**Application by Fosse Green Energy Ltd for an  
order granting development consent for the Fosse  
Green Energy solar farm**

**Post - Hearing Submissions in  
relation to ISH2:  
Comments on the Draft  
Development Consent Order**

**by North Kesteven District Council  
(ID FD1E96A6C) for Deadline 1**

**NKDC reference: 23/0325/NSIP**

Proposed Permissive Paths Plan

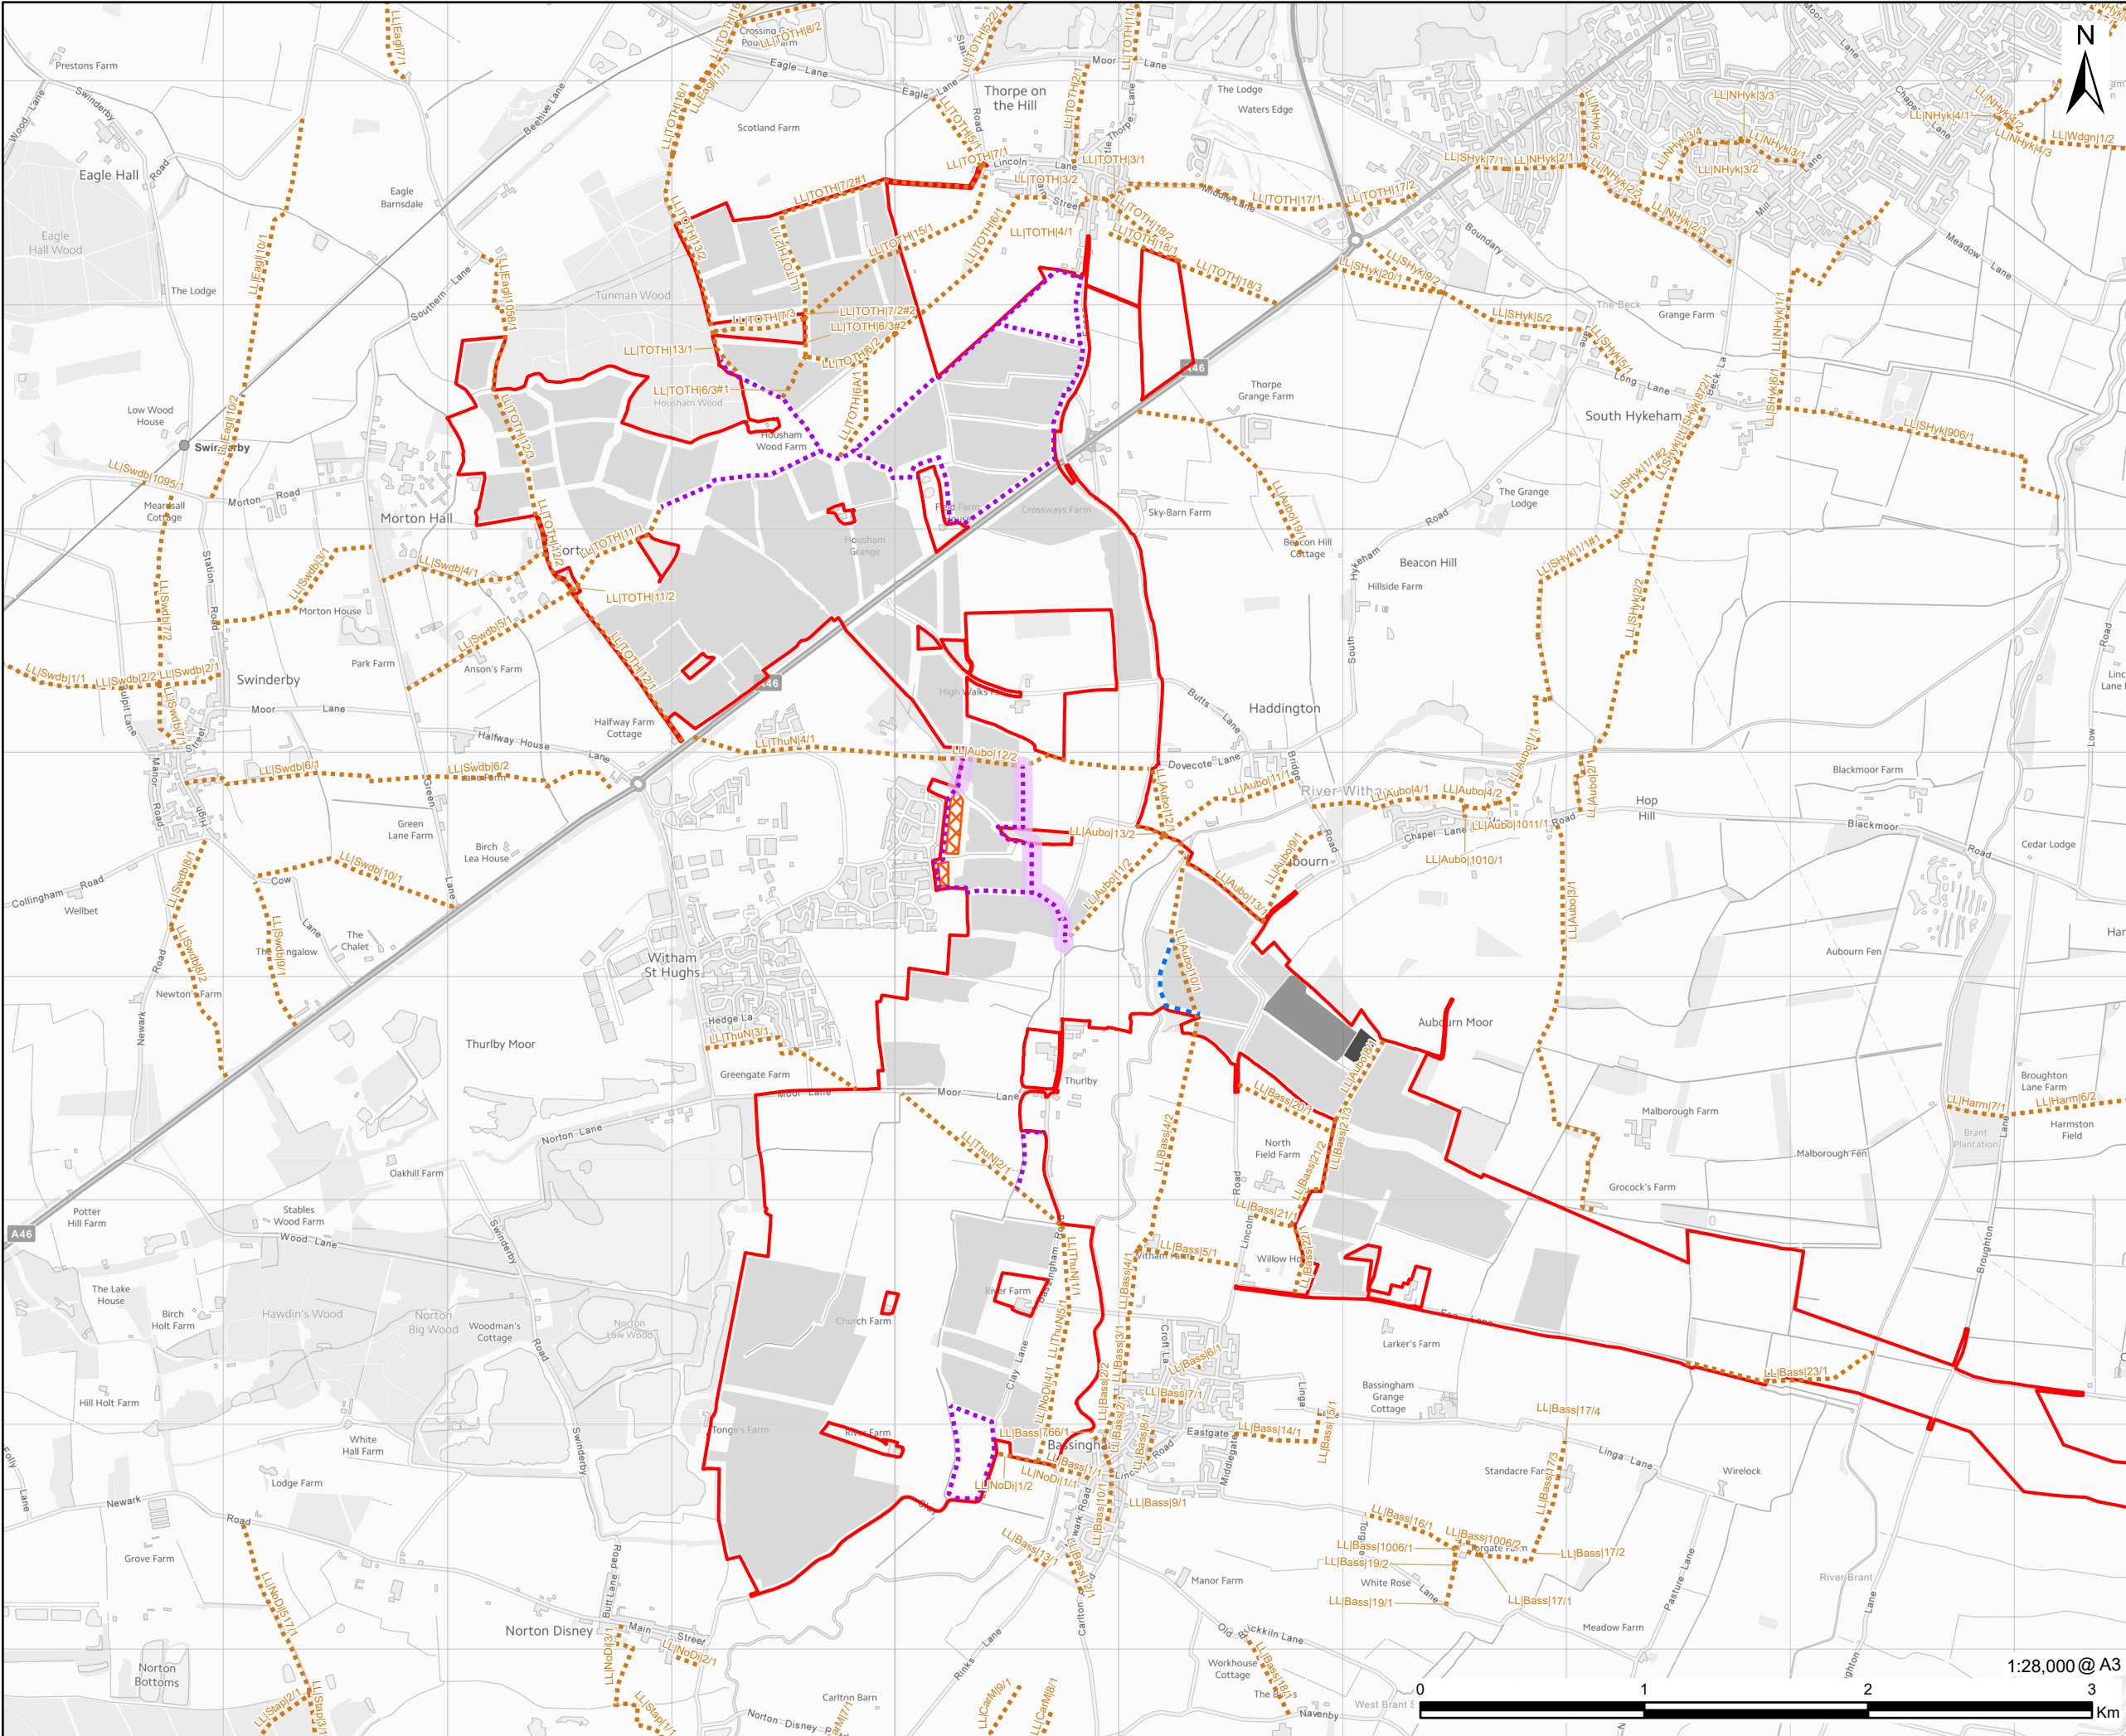
<p>Article 2 interpretation: 'permissive paths' and Requirement 17</p>	<p>Defined as 'new paths providing restricted public access within the Order limits along the routes shown on the framework landscape and ecological management plan'. This raises the following points:</p> <ol style="list-style-type: none"> <li>1. The definition as 'restricted' public access is considered opaque and inadequate. For instance, the path could comply with this by being open for only a few days a year</li> <li>2. The definition should set out clearly what permissive access is proposed including duration of permitted access</li> <li>3. Requirement 17 in Sch.2 of the draft DCO at present does not require the Undertaker to actually provide any permissive paths</li> <li>4. When coupled with the powers in the DCO to close any or all public rights of way (PRoW), this means that in theory there could be much greater impact on PRoWs than has been assessed in the ES</li> </ol>
